re:	<b>Response to City Comments - Hydrogeological Review of</b>
	Groundwater Conditions
	Proposed Residential Development – Barrhaven Conservancy
	Borrisokane Road - Ottawa – Ontario
to:	Caivan Communities – <b>Hugo Lalonde –</b> <u>Hugo.Lalonde@Caivan.com</u>
date:	June 8, 2021

file: PG5036-MEMO.12

## **Rideau Valley Conservation Comment Summary**

FILTRATION SYSTEM DETAIL TYPICAL SECTION N.T.S.

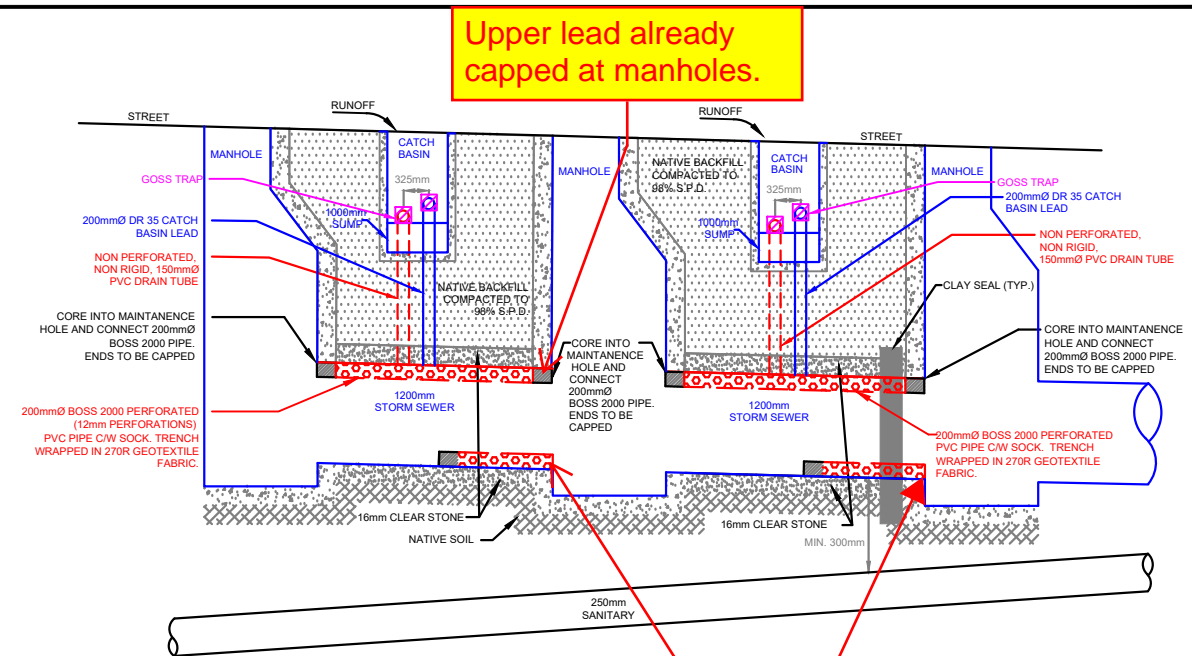
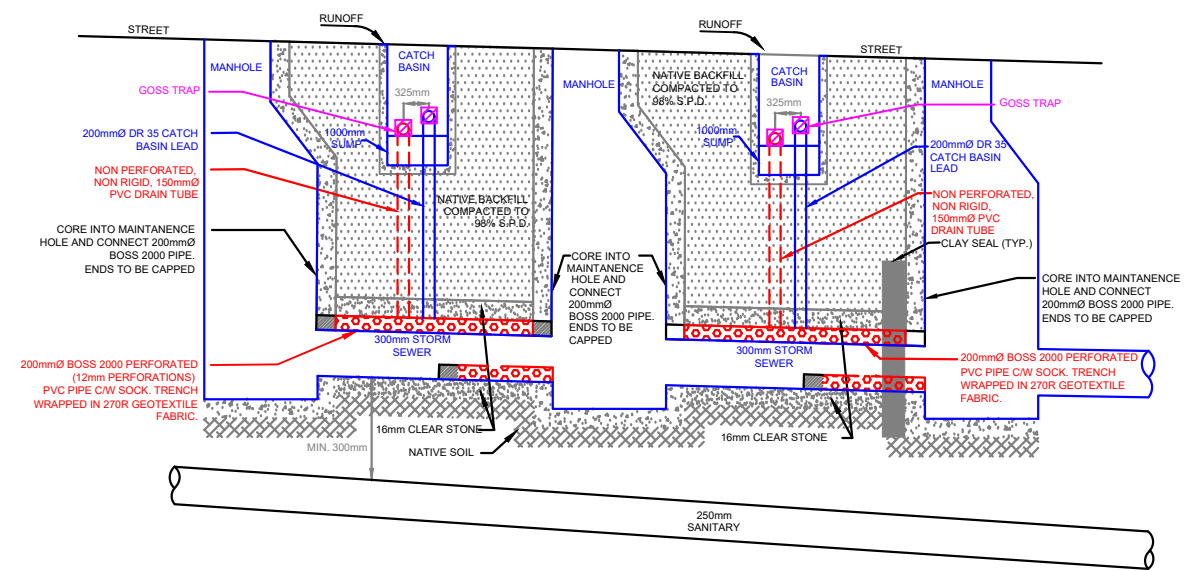
- Page 3 of 8 Section A A buried perforated pipe system is to be installed throughout. Given that the water table is high, it seems that the system is designed to drain the existing and future groundwater table (and recharging water) and maintain the groundwater at the elevation of the pipe's bottom.

The Etobicoke System is proposed to be constructed within the ROW of all streets within the proposed subdivision. The vertical alignment of the proposed systems was reviewed based on sanitary and storm trunk profiles provided by DSEL. The base of the Etobicoke System granular material, that provides the filtration, extends to approximately 0.15 m below the base of the storm sewer. The base of the Etobicoke System is considered to be encompassed entirely within the native brown silty clay layer as shown in Figure 1 attached.

The subgrade below the granular filtration material will consist of the native brown silty clay crust that was observed and measured to have physical and mechanical properties that exhibit behaviour associated with a material that is generally found in an unsaturated state. As the material has consistent properties associated with unsaturated materials, the

Etobicoke System is considered to have a construction elevation that would remain above the groundwater table.
